Online Comment

Application H16-0882-25
Location 65 HOLBEACH ROAD SPALDING PE11 2HY
Proposal Change of use from a single dwelling to dental surgery including alterations, additional gravel parking, improvements to existing access and plant shed

Name Greg Watkinson, Principal Conservation Officer
Address Council Offices Priory Road Spalding PE11 2XE

Date Submitted 22-10-25
For/Against Comments

**Drawing**  
 Proposed General Arrangement Drawings

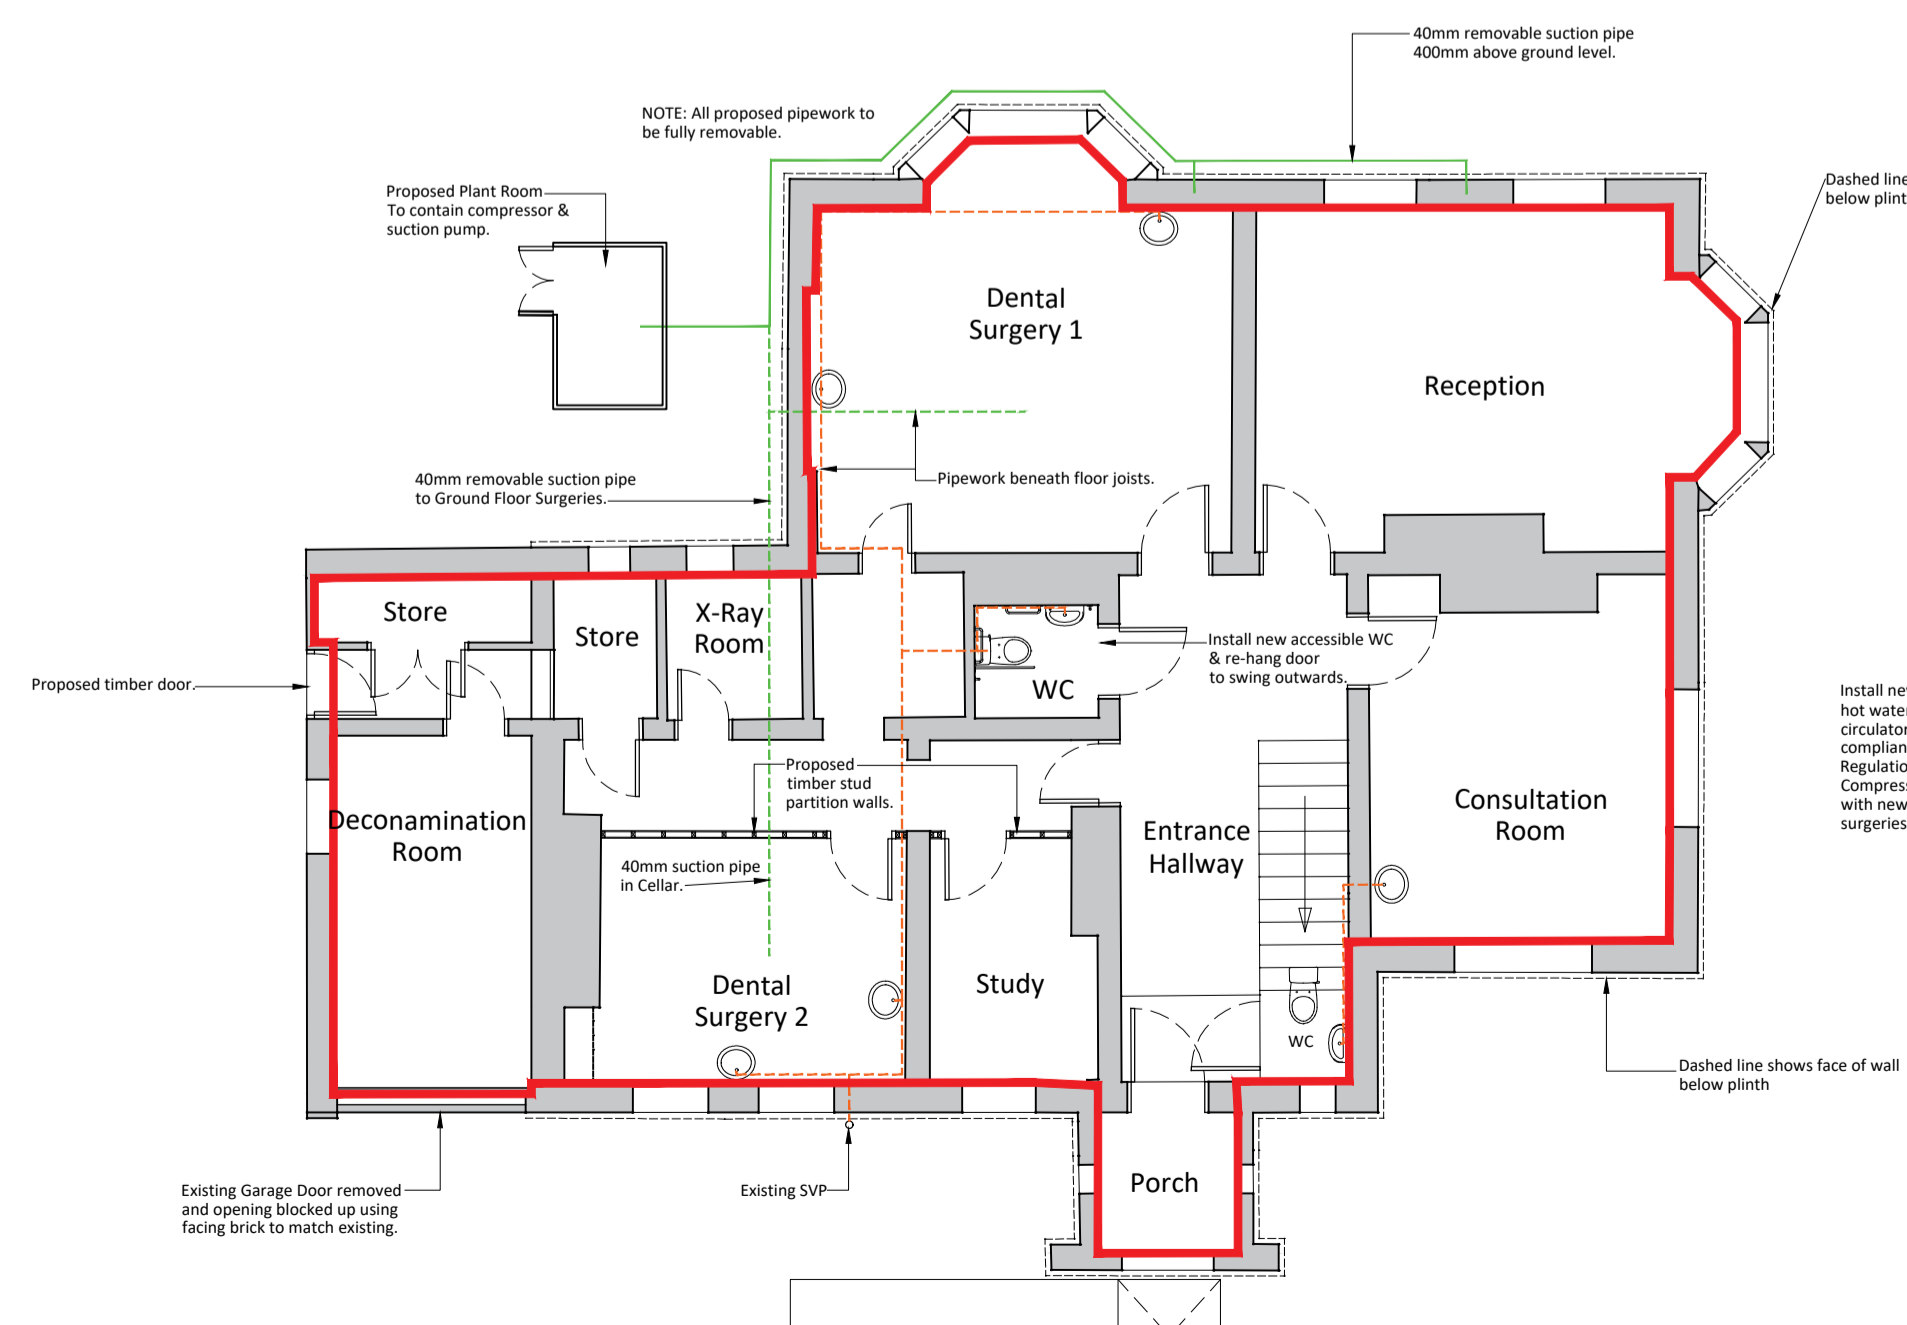
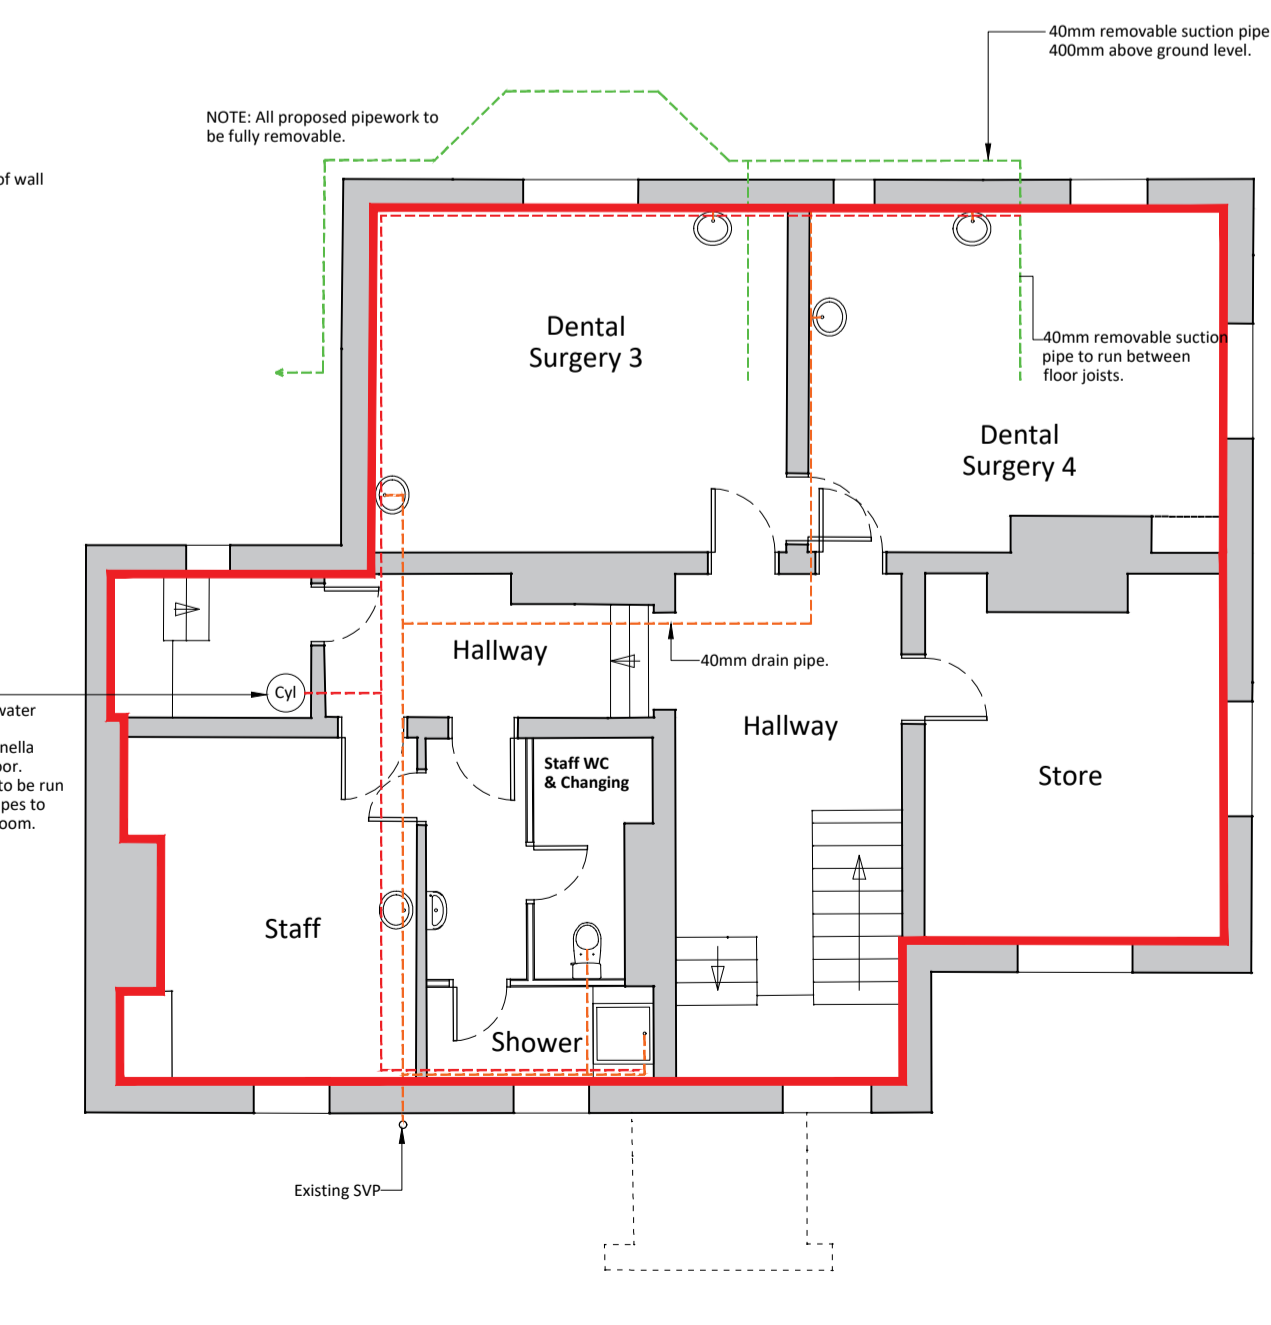
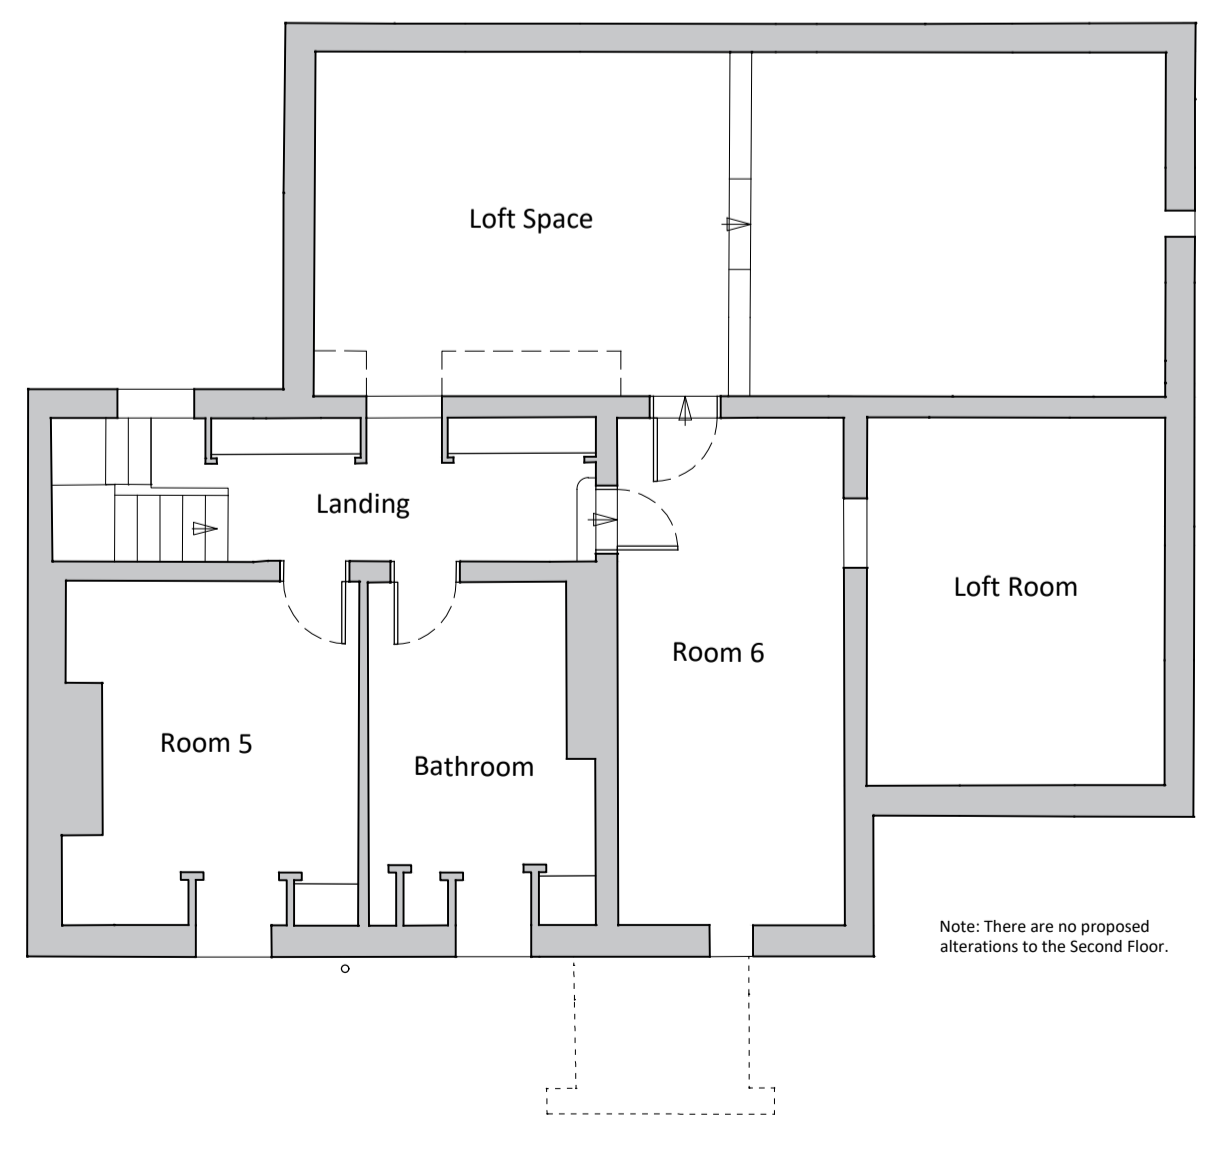
The proposed conversion of this site to use as a dental surgery seeks only extremely minor internal alterations, inclusive of a small amount of additional subdivision of ground floor rooms and 1st floor bathroom using reversible stud walling, the routing of new utilities (namely air, drainage and hot water) from external plant to further rooms, which requires only minor incision into walls, and is proposed as fully reversible.

Exterior alterations include the bricking up of existing garage door opening, the erection of a small plant room lean-to in timber on the rear elevation, as well as the reformatting of the driveway and a portion of the front garden for use as a car park for customers.

None of the proposed alterations risk undue or unjustified harm to the special interest in the listed building. The proposed new subdivisions internally should not remove readability of the original layout and are quite minor in scale, as well as being easily reversible. The proposed utility works bear a negligible impact upon the asset.

Regarding external works; the most major shall be the bricking up of the garage door. There is no value inherent to this portion of the building being used as a garage, and the extant doors appear to be a mid-late C20th affectation. The proposed lean-to is quite modest and features only to rear and lesser elevations. Alterations to the driveway are relatively minor, and do not strip character from the garden setting of the site.

Less than Substantial Harm could be said to be identified in the subdivision of the internal layout and in the erection of the modern timber lean-to. However, I would suggest that the applicants justification for this is clear and convincing in claiming that these works are important to the use of this site as a dental surgery, which would be securing an optimum use for this site, presently unused.

I am therefore satisfied that this application may be approved subject to conditions which require brickwork and mortar to match the existing, and which requires the removal of the proposed timber lean-to and making-good of associated surfaces should the site cease operation as a dental surgery, unless otherwise agreed in writing by the LPA.
